**Consultation Response from KC Highways Development Management****Date Responded: 23/02/23 | Responding Officer: R.Kinder | Responding Ref: K2-20NW/6**

2022/91477 Land off Lindley moor Road, Lindley.

**RECOMMENDATION:** Further information is required regarding the following issues, which are detailed in the main body of the report:

REV	DATE	DESCRIPTION
PROJECT		LINDLEY MOOR ROAD LINDLEY MOOR
TITLE		PROPOSED INTERNAL VEHICLE TRACKING
SCALE		1:500 @ A1
DRAWING		2061-102
DATE		25.04.2022

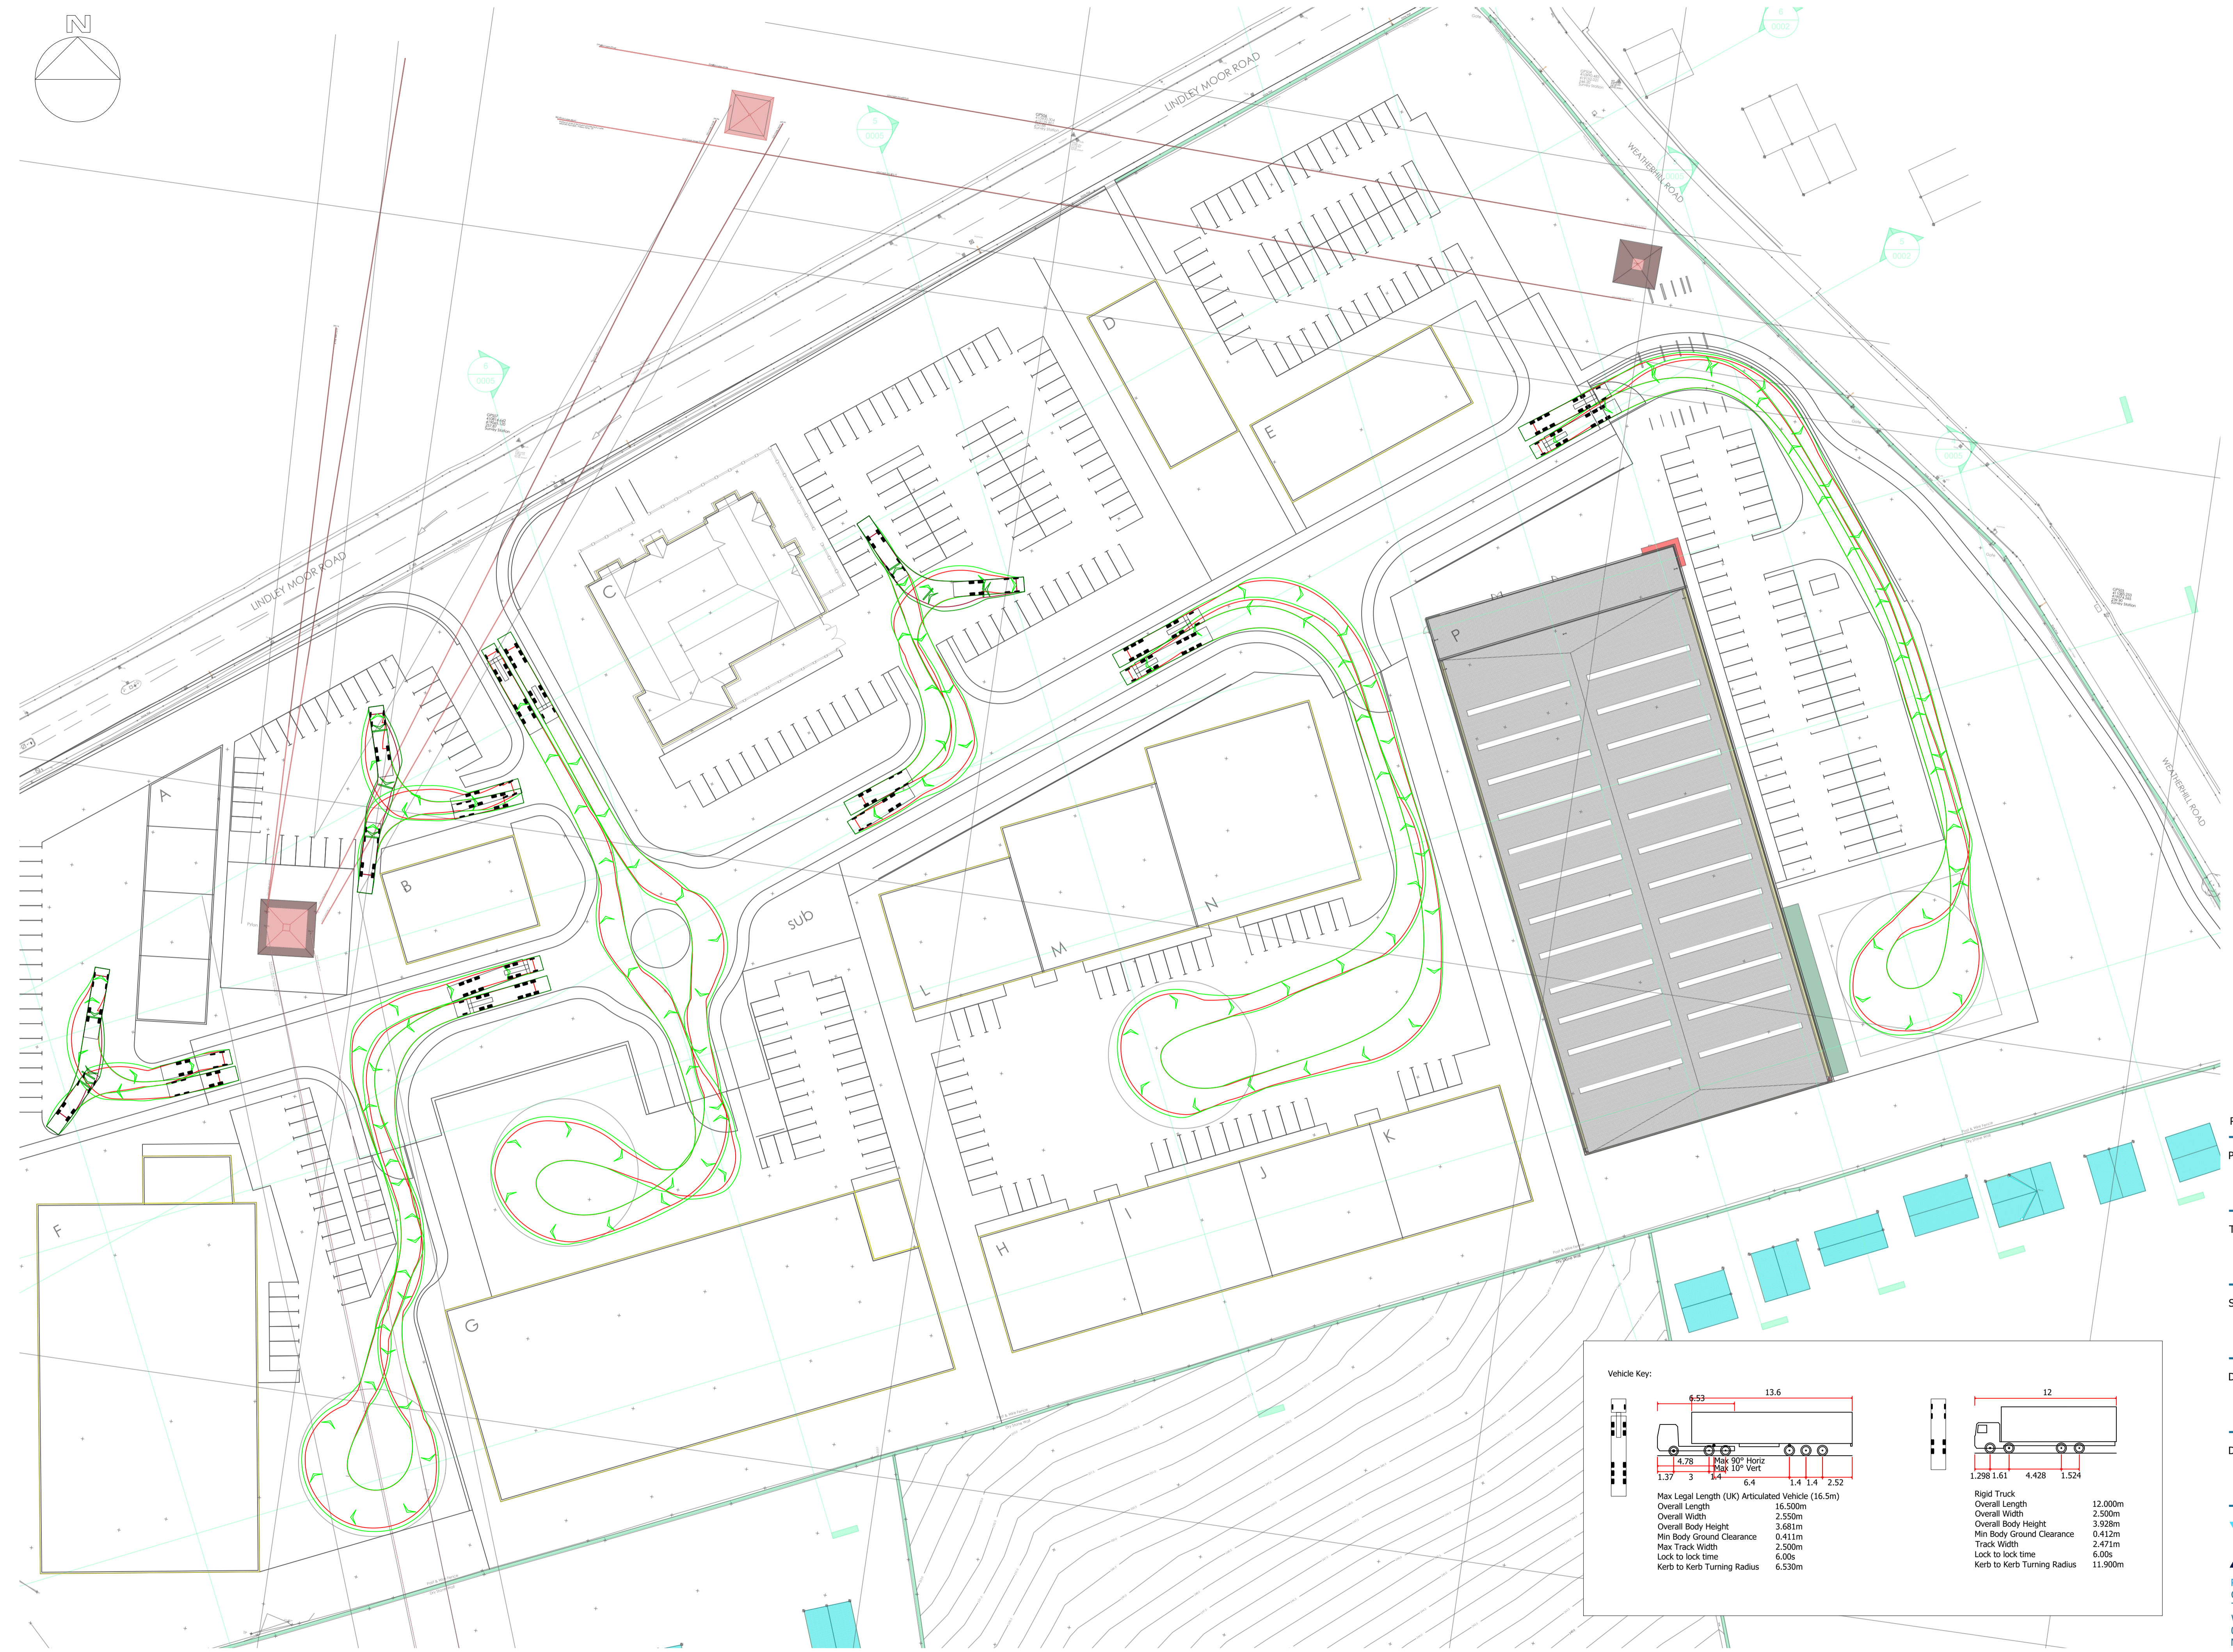
Various amendments to the site layout and parking provision are required, with amended plans including construction details, vertical alignment/gradient details, junction/forward visibility details and additional Swept Path Analysis (SPA) etc. Once agreed in principle, the layout must be subject to a Stage 1 Road Safety Audit (RSA Brief and Team to be agreed with HDM);

- a carriageway width of 7.3m minimum.
- Typical cross section of 2m footway, segregated cycle way, 7.3m carriageway, segregated cycleway and 2m footway.
- 33m forward visibility splays within the adopted highway.
- a balance crossfall either side of the carriageway centreline (cross and long sections required).

The proposed parking provision needs to be carefully considered with the correct provision and sizing of parking bays, enough disabled provision swept paths of vehicles manoeuvring in and out of bays where space appears tight in some instances.

The internal layout has a roundabout proposed and should comply with CD116 Geometric Design of Roundabouts.
